WEST SUSSEX COUNTY COUNCIL CONSULTATION

TO:	Arun District Council FAO: Amber Willard
FROM:	Highways, WSCC
DATE:	08/01/2019
LOCATION:	1 Church Farm Cottages, Church Road, Yapton, Arundel, BN18 0EP
SUBJECT:	Y/80/18/PL Change of use from cowshed to separate residential unit - This is a departure from the development plan - This application may affect the setting of a Listed Building.
DATE OF SITE VISIT:	N/A
RECOMMENDATION:	☒ Advice ☐ Objection ☐ Modification ☐ No Objection ☐ More Information ☐ Refusal
S106 CONTRIBUTION TOTAL:	£N/A See below for breakdown.

Block Plan 1:500

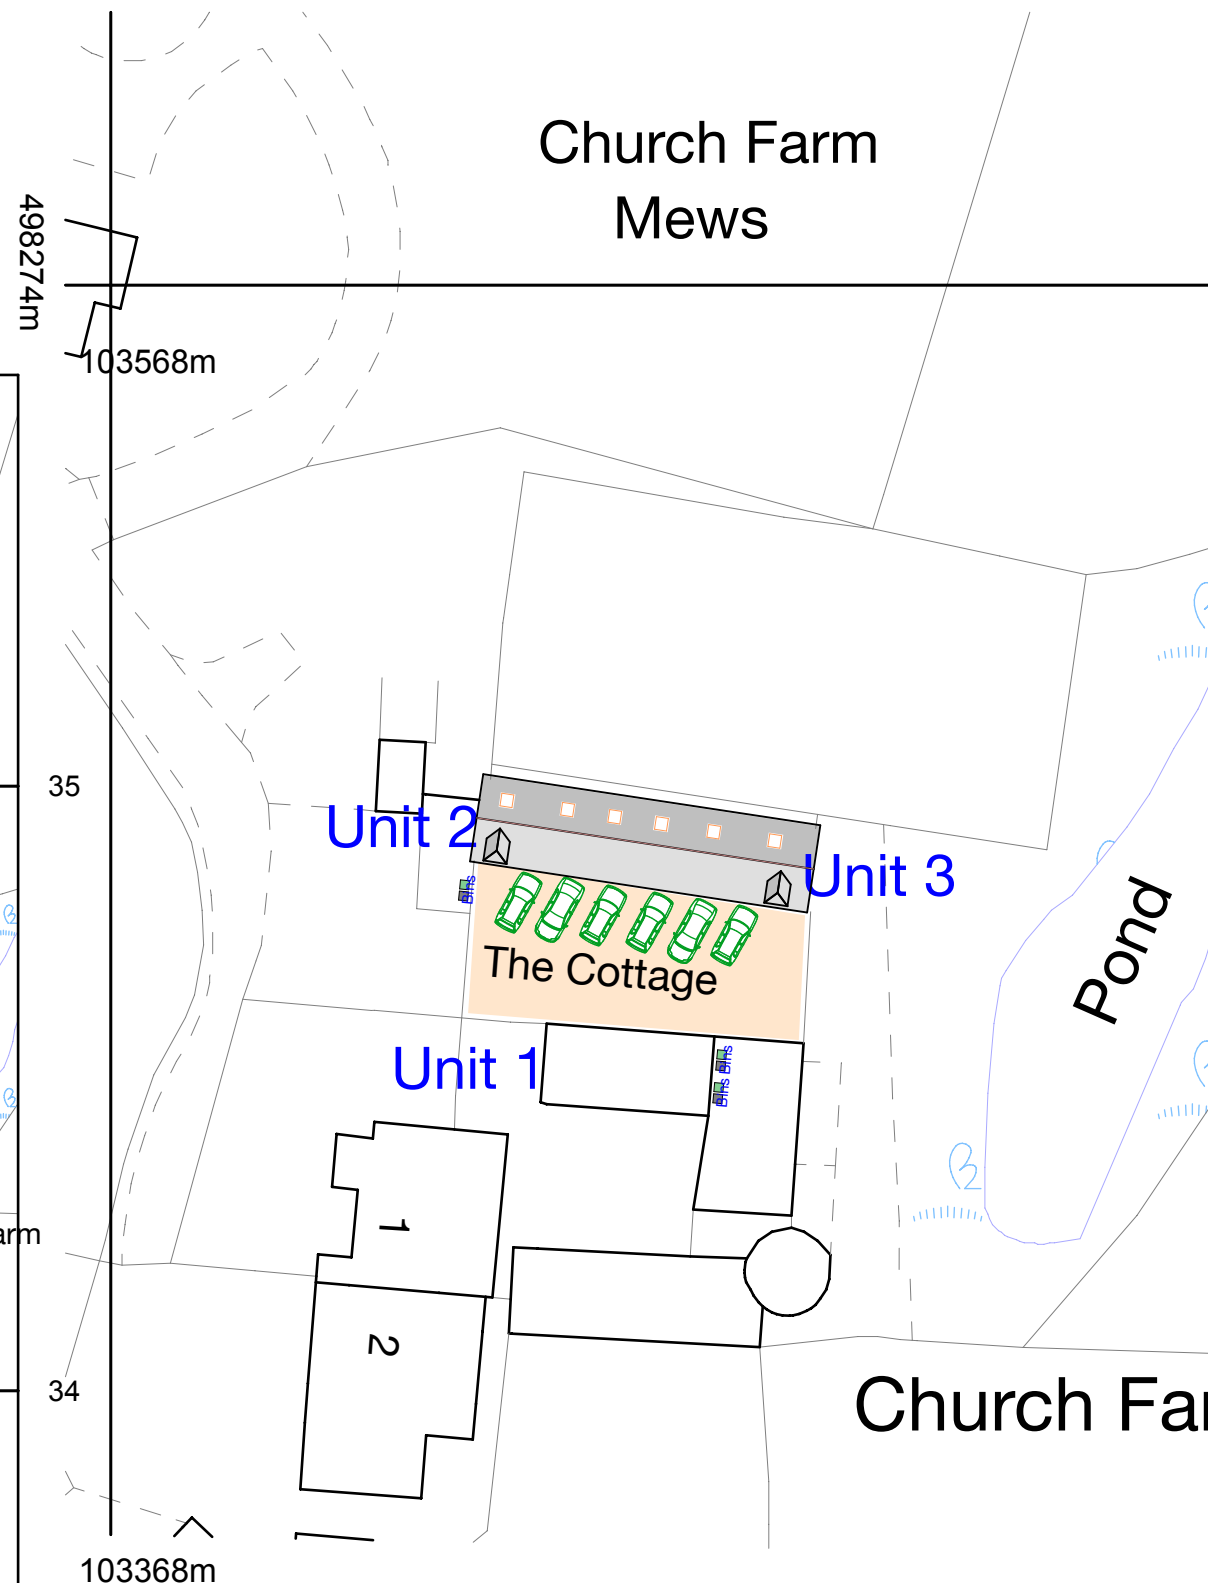
The applicant has shown 6 car parking spaces for the development which would be sufficient for a development of this size. The applicant has demonstrated that the parking spaces meet the minimum dimensions stated in Manual for Streets (MfS) of 2.4m x 4.8m with sufficient space to manoeuvre.

The site is approximately a 10 minute bicycle ride from Barnham train station and a 10 minute walk from local bus stops, shops and amenities. The applicant should provide secure and covered cycle storage to encourage the use of sustainable transport modes.

No part of the development shall be first occupied until the car parking has been constructed in accordance with the approved site plan. These spaces shall thereafter be retained at all times for their designated purpose.

No part of the development shall be first occupied until covered and secure cycle parking spaces have been provided in accordance with plans and details submitted to and approved by the Local Planning Authority.
